8th February 2022

Re: Eastern Creek Recycling Ecology Park MOD10 (MP06_0139-Mod-10) – Response to request for additional information

This memorandum has been prepared to respond to the request for further information from DPE and respond to proposed conditions of consent within the provided feedback from government agencies to support a timely approval of the Modification Application.

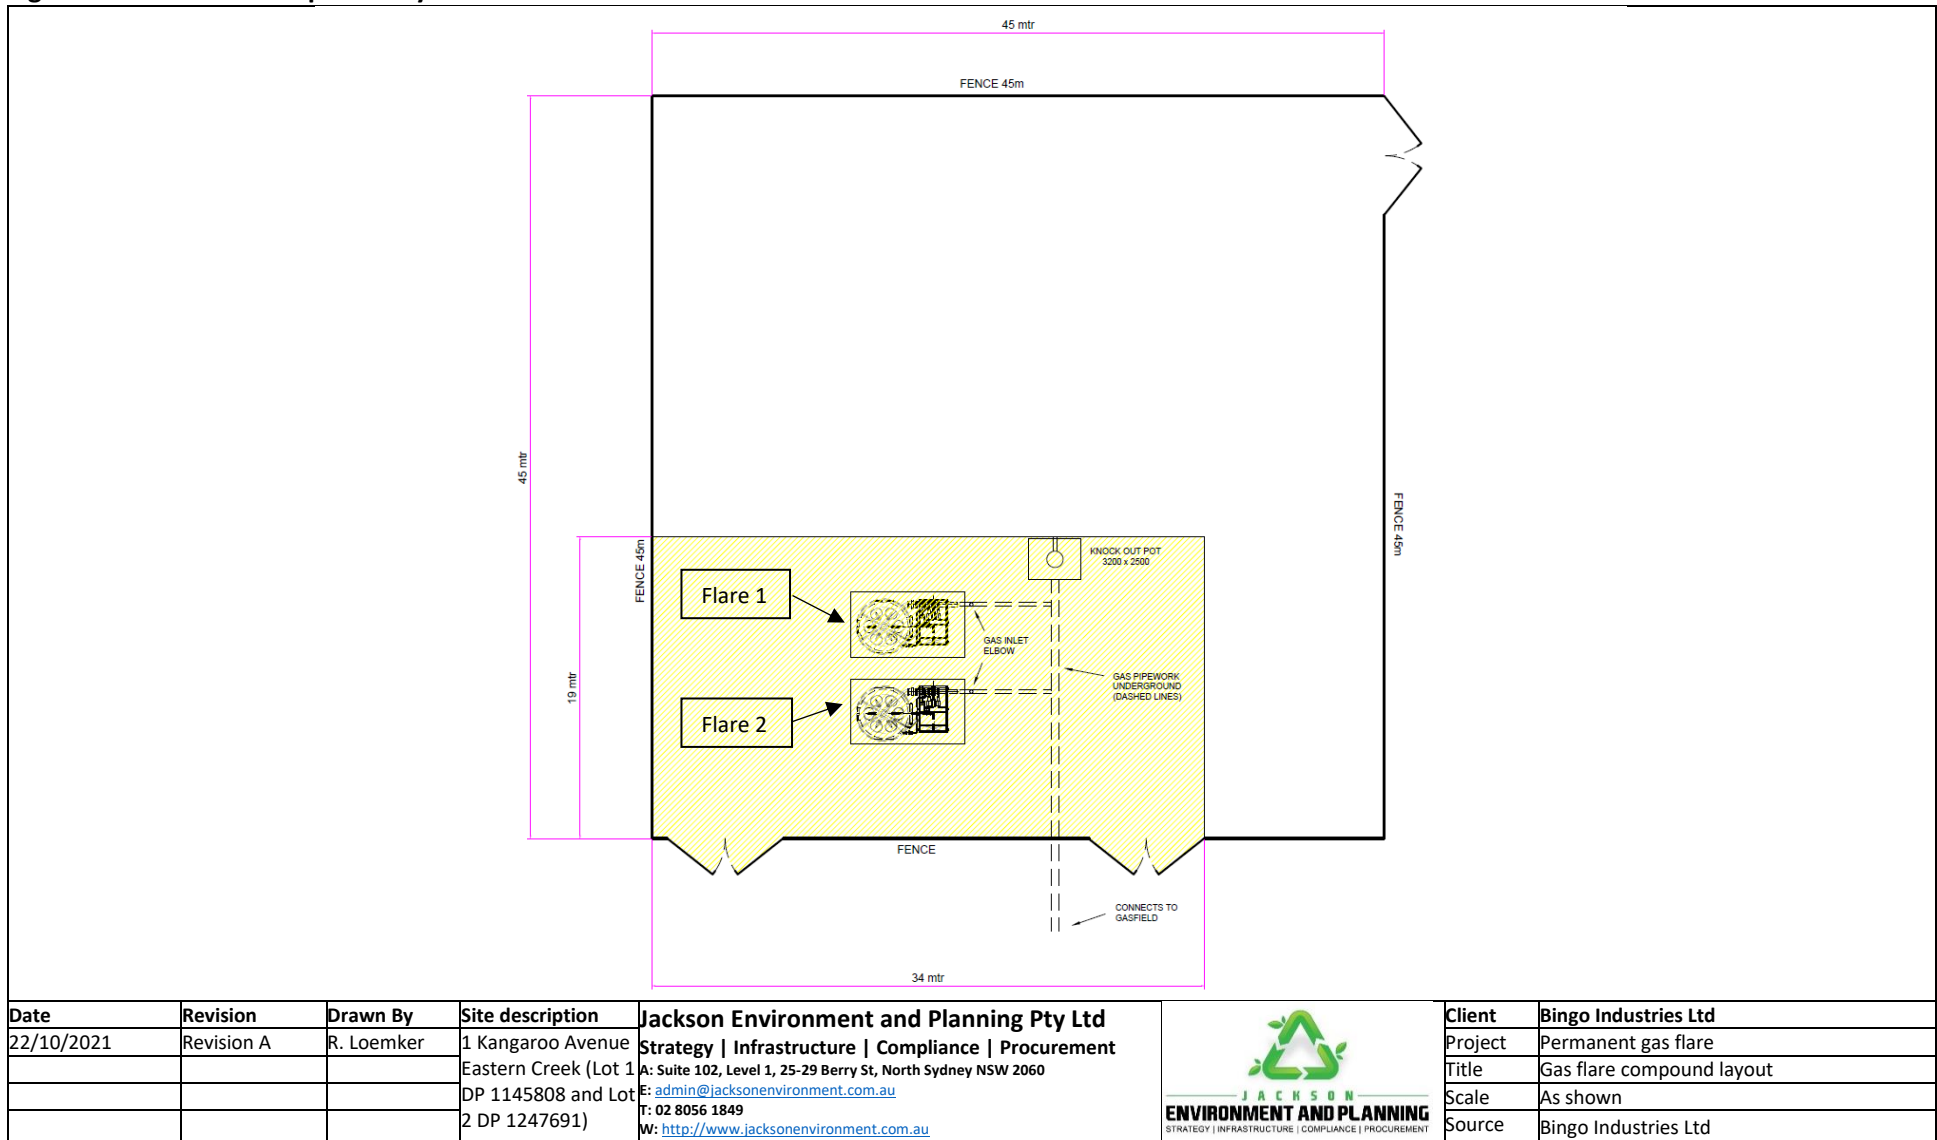
The Department notes the modification application requires certain works which the Applicant deems to be already approved within the scope of the original approval under MP06_0139. These works include:

- *Installation of 12 additional gas collection wells*
- *Replacement of a portion of the existing 160mm header line with a new 355mm header line*
- *Extension of the LFG network through the installation of additional 355mm header line*
- *Construction of in-line barometric condensate traps to remove any condensate build up*
- *Remedial works required to compact the clay liner back to its previous state.*

Given the scale of the works required within the landfill void and the limited details provided in the original (2009) application, the Department requires further information which considers the potential construction impacts of the above works.

As described in Section 1 of the Statement of Environmental Effects supporting the Modification Proposal, the construction of the landfill gas (LFG) collection system is subject to a separate approval (the Original Application - MP 06_0139) and has not been assessed within the Modification Application.

The location/distribution of the temporary gas collection system and LFG flares are shown in Figure 3.2 of the Statement of Environmental Effects supporting the Modification Proposal. Importantly, the impacts associated with the construction of this infrastructure are similar to those associated with the landfill gas collection infrastructure for which the DPE has requested further information, specifically with regard to construction impacts.

Notwithstanding the above, to assist with assessment and determination of the Modification Application further details on the potential construction impacts of these activities has been provided in Table 1. Given the minor nature of the works and the location within the landfill void, the assessment has been limited to key environmental aspects where there is potential for impacts. Namely, air quality, noise and vibration and soil and water. A summary of the construction works relevant to the environmental assessment in Table 1 is provided in Section 3.3 of the Statement of Environmental Effects (SEE). Importantly, any construction related impacts will occur over short time periods (construction activities would be undertaken over a period of approximately two months) and progressively in accordance with the EPA approved landfill filling plan. A construction program is provided as Section 3.3.5 of the SEE.
